METROLINK RAILWAY ORDER – COMMENTARY ON TII RESPONSES – MARCH 2024

Author – Peter Twamley FRIAI

Date – 25 March 2024

Drawing Title	METROLINK - STRUCTURES O'CONNELL STREET STATION PROPOSED STREET LEVEL DESIGN	Drawing Status	S0
Drawing N°	ML1-JAI-SRD-ROUT_XX-DR-Y-02071	Plan Drawing N°	ML-ST 305 F-G1
Scales Original Size A1	1:250	Sheet	1 of 7

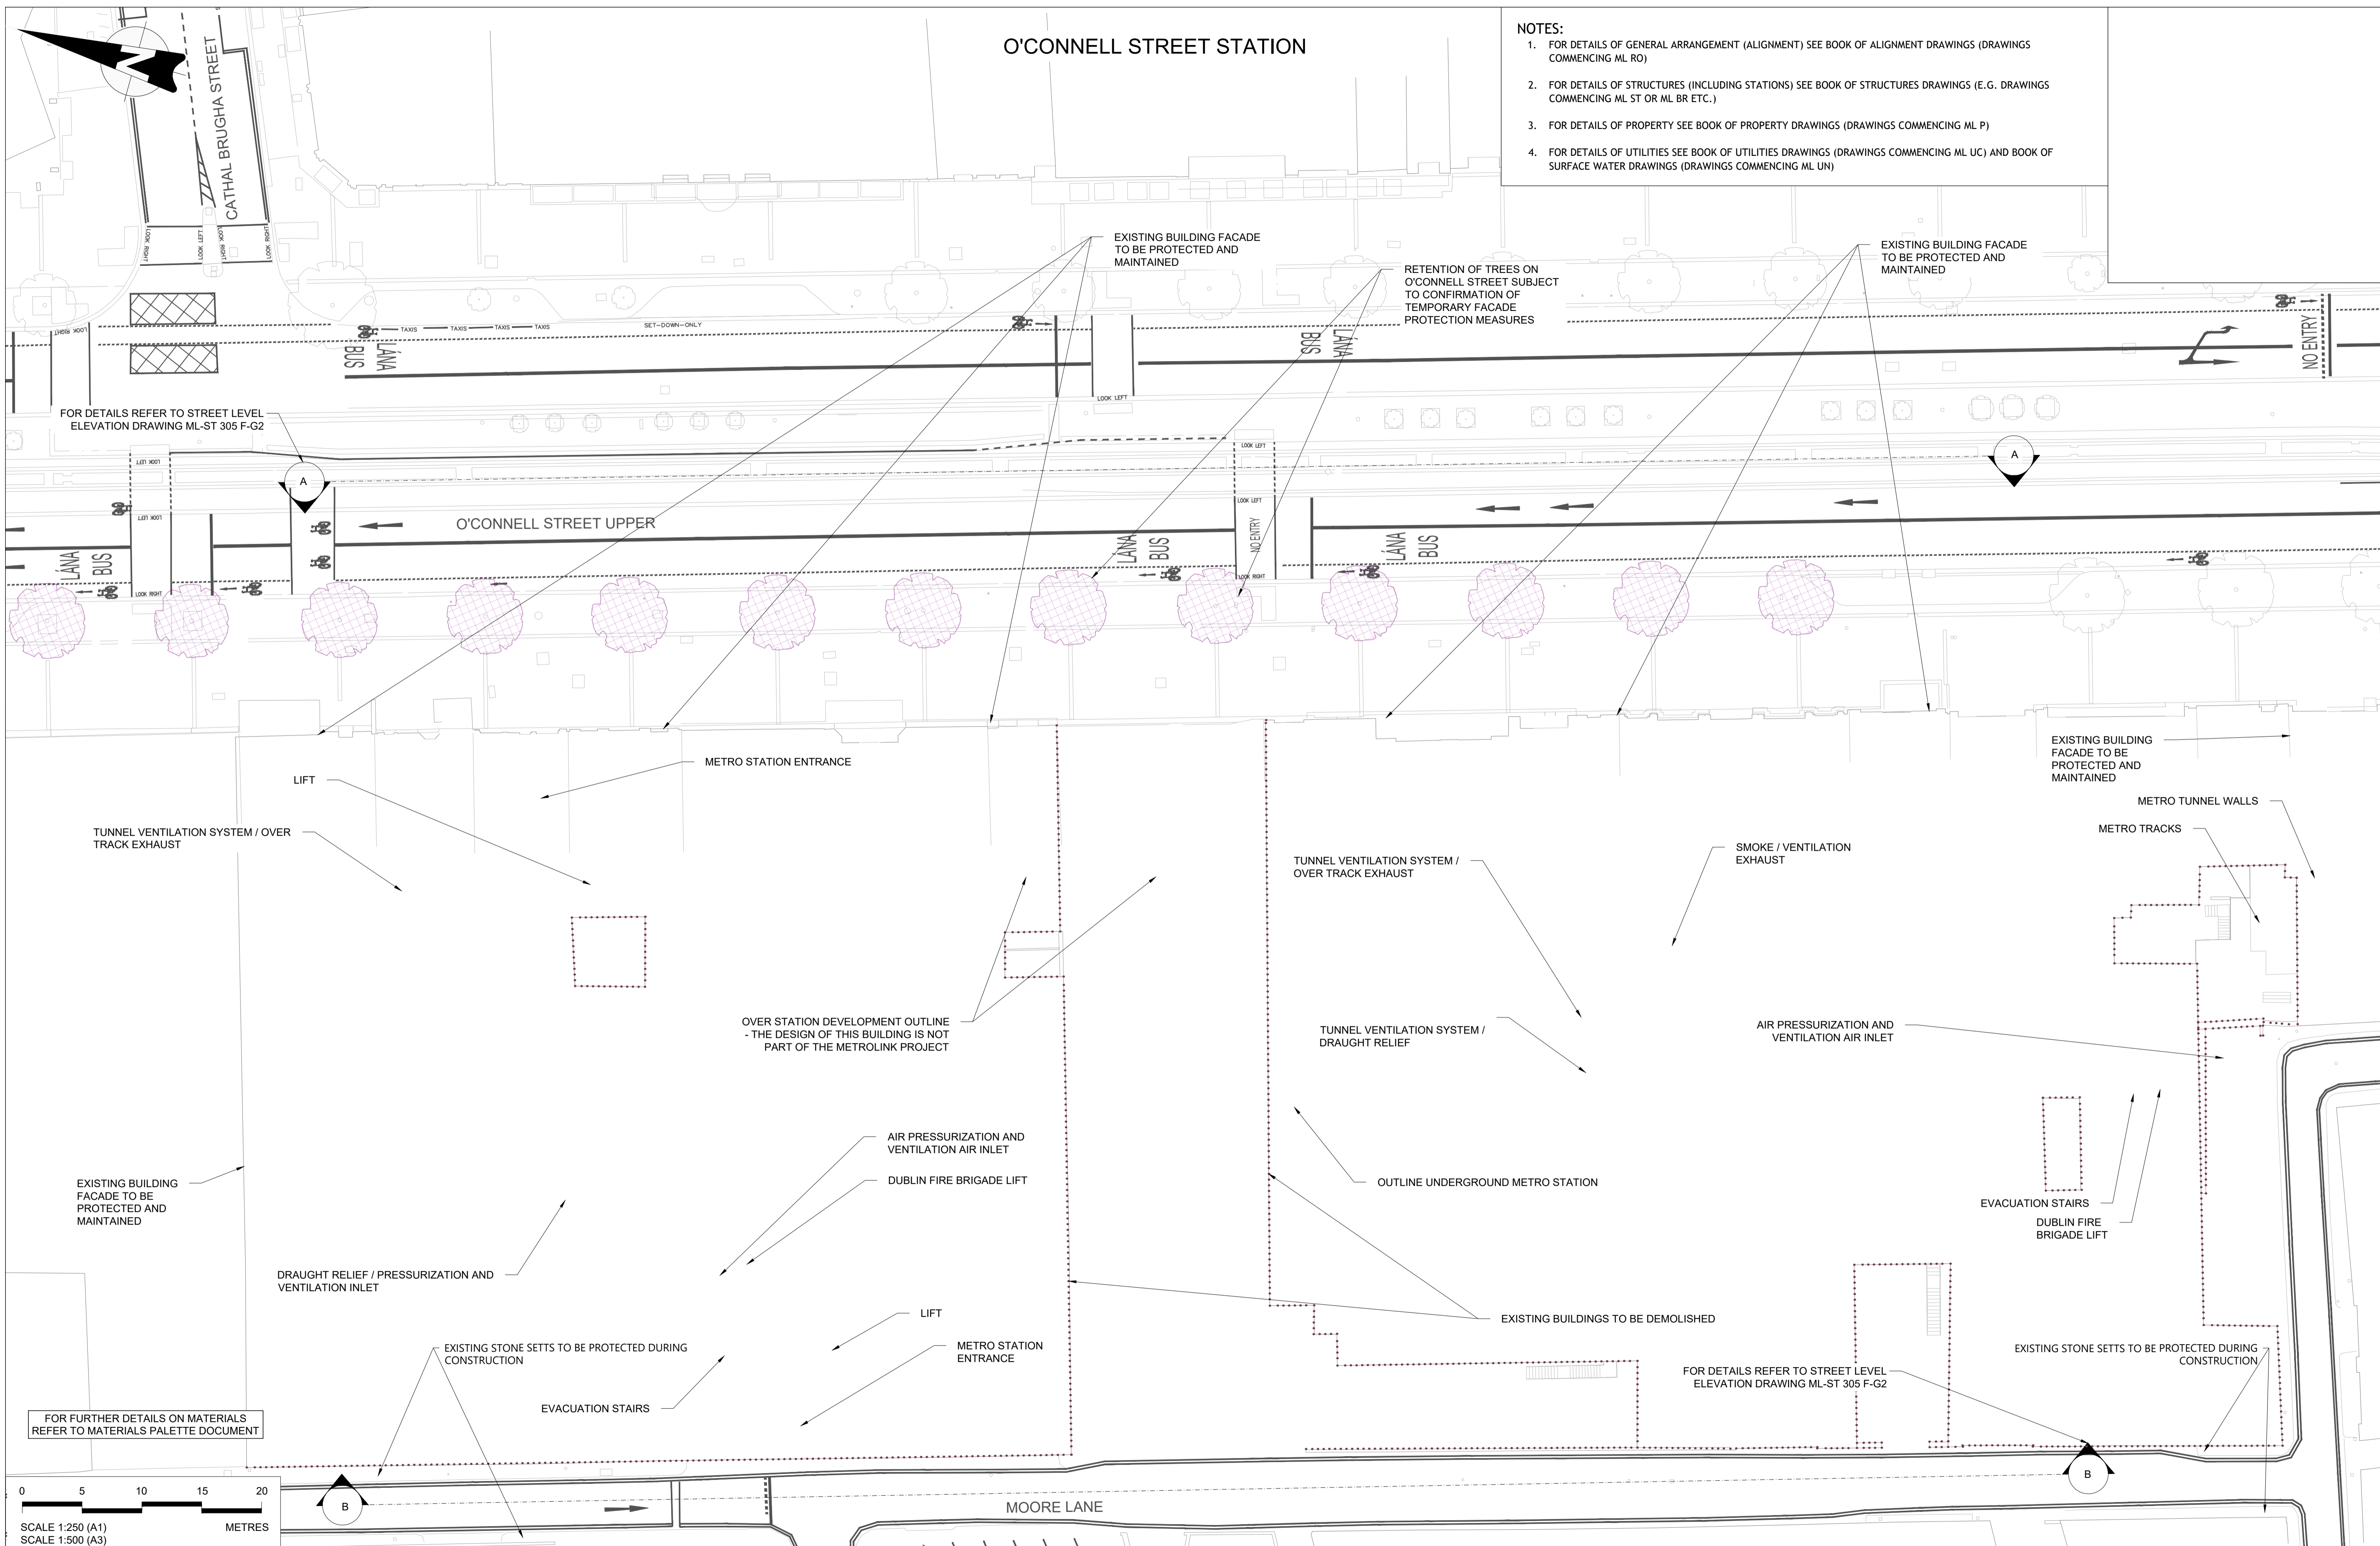
6. THE RELOCATION OF THE STATION AT UPPER O'CONNELL STREET IS DICTATED BY THIS LOOP TO TARA STREET

This location no longer connects with the Red Line Luas which feeds both the main line stations of Heuston to the West and Connolly to the East

TARA STATION

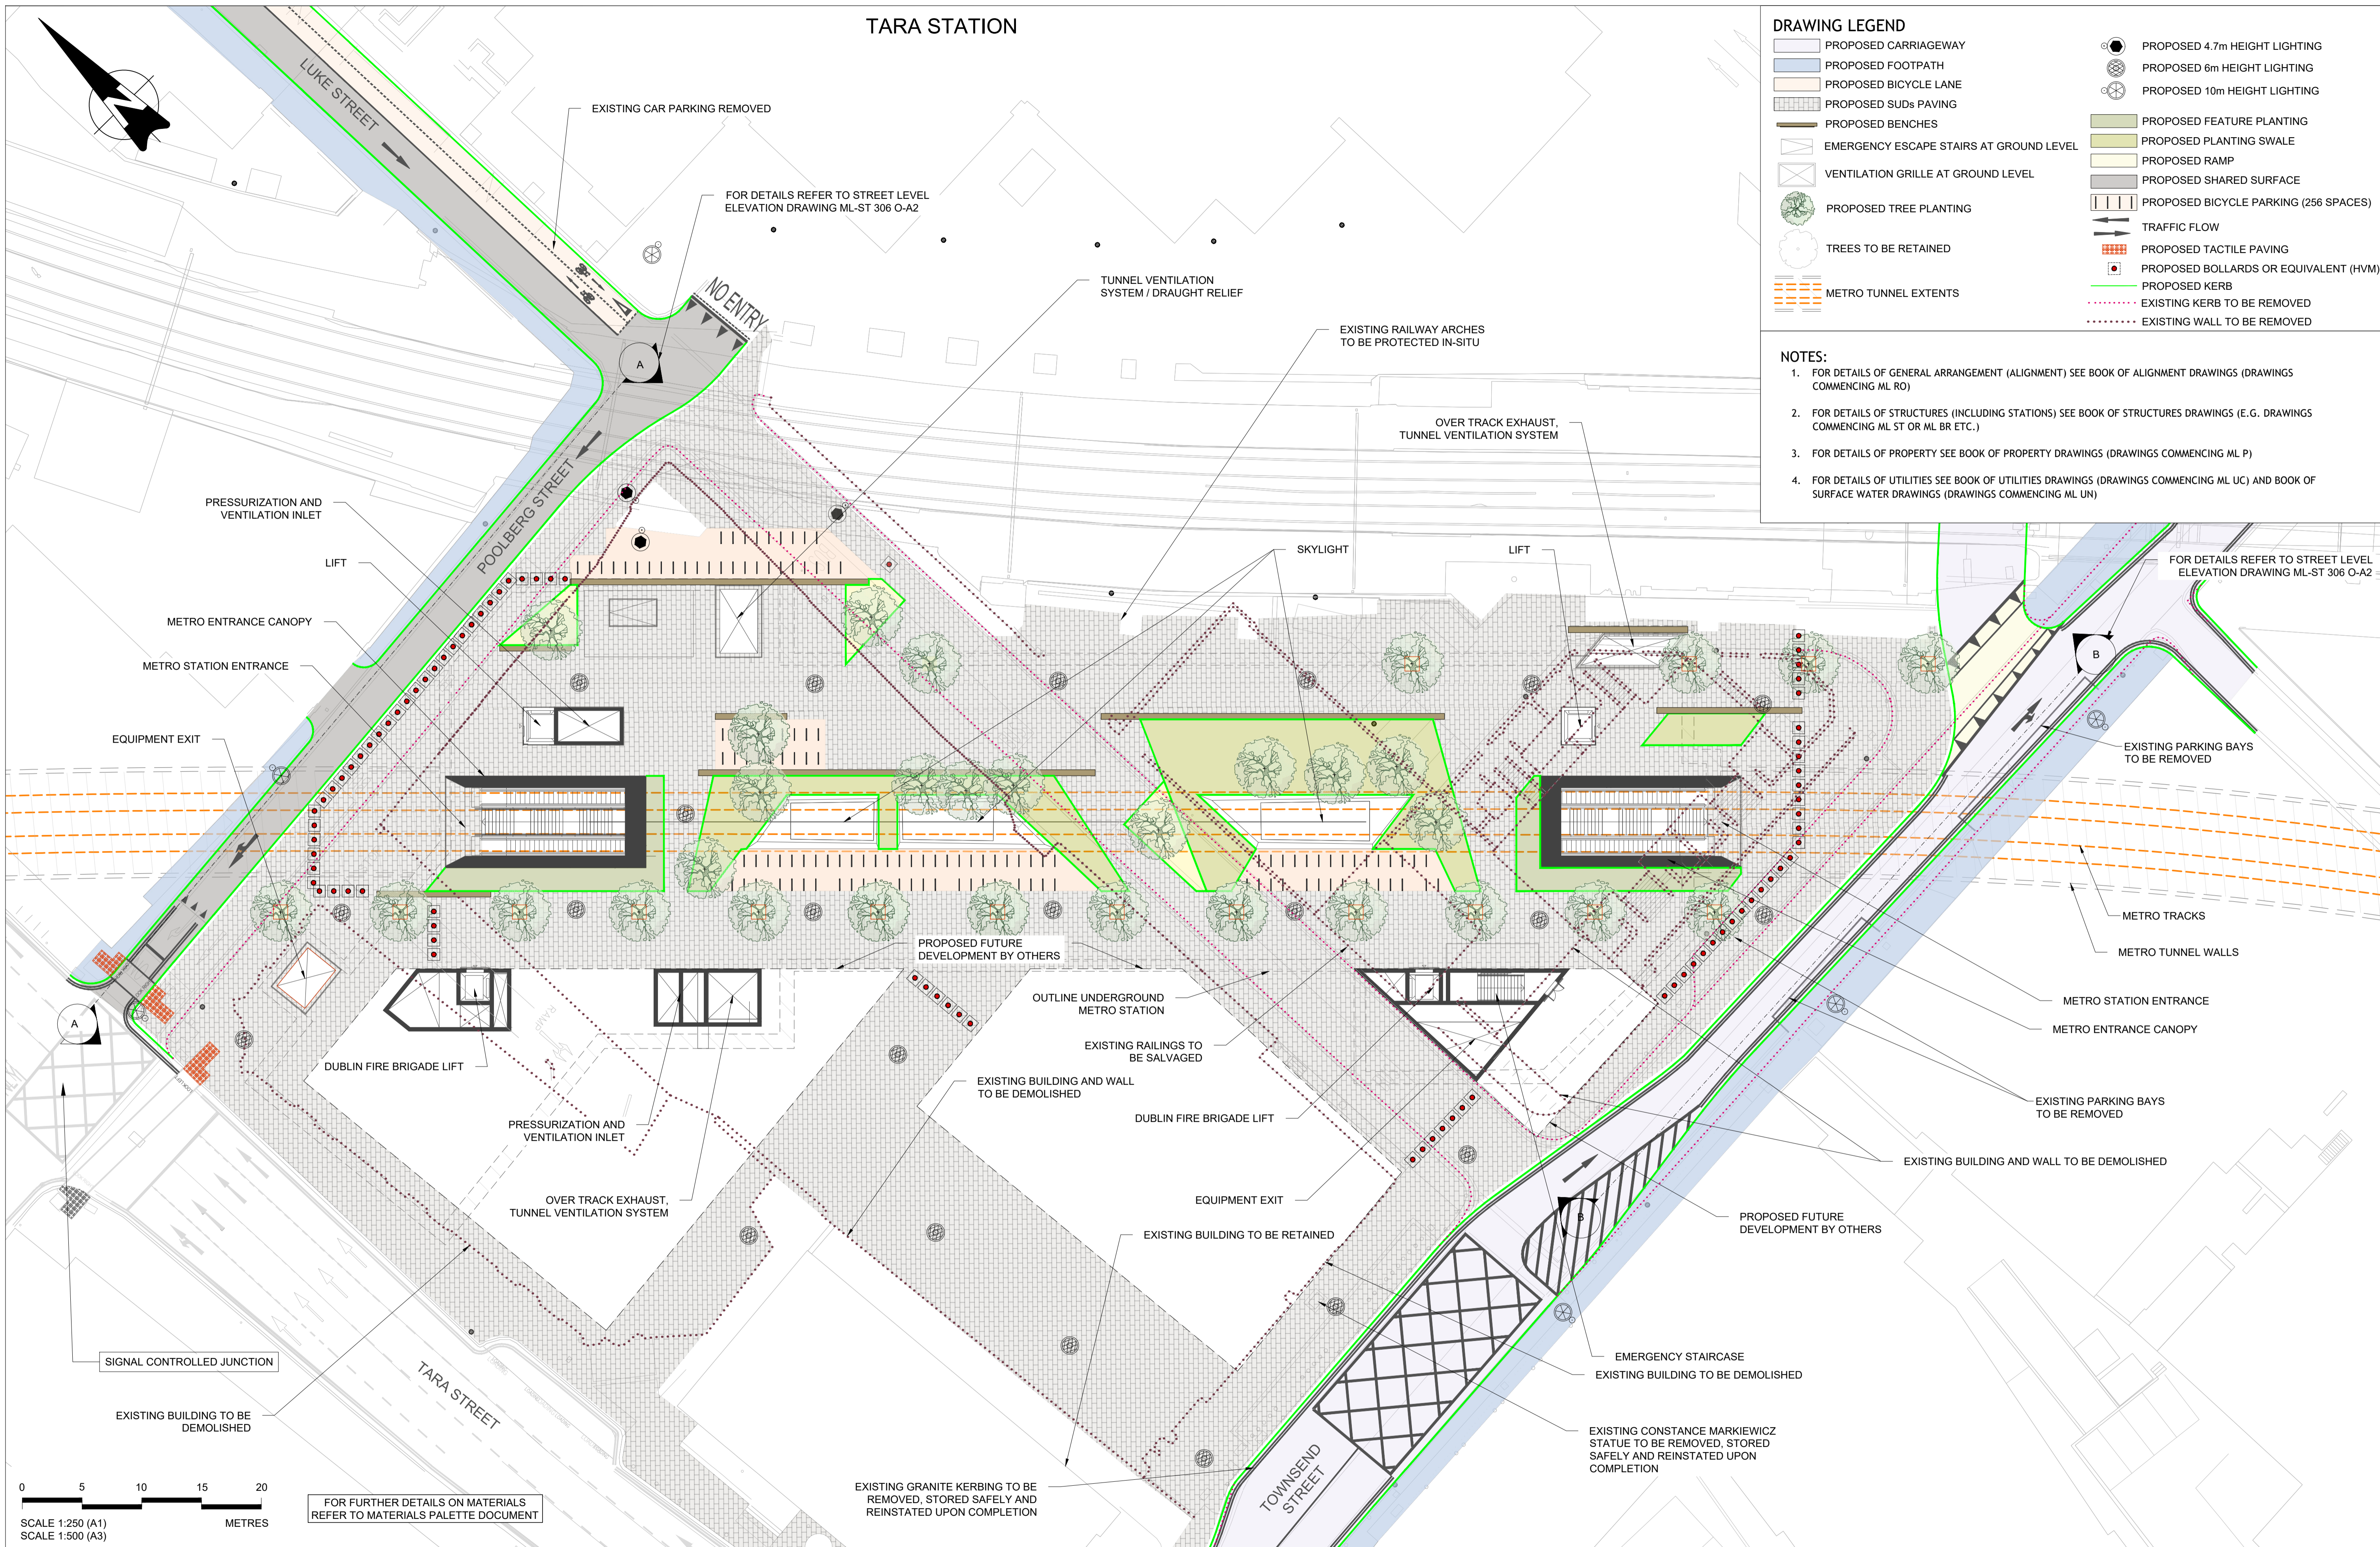
5. THE DIVERSIONARY LOOP UNDER TRINITY COLLEGE TO CONNECT TO THE DART OVERGROUND AT TARA STREET IS BOTH UNWARRANTED AND UNNECESSARY

You have already heard at length from others on all the difficulties being caused by the proposed CPOs and demolitions in this location.

The curvature of this route to Tara Street causes the proposed SSG station to move to the east side of the Green more remote from the Luas line and causes the O'Connell Street station to move further north up O'Connell Street.

Additionally this proposed route runs under Trinity College with all the associated disturbances requiring extensive mitigation.
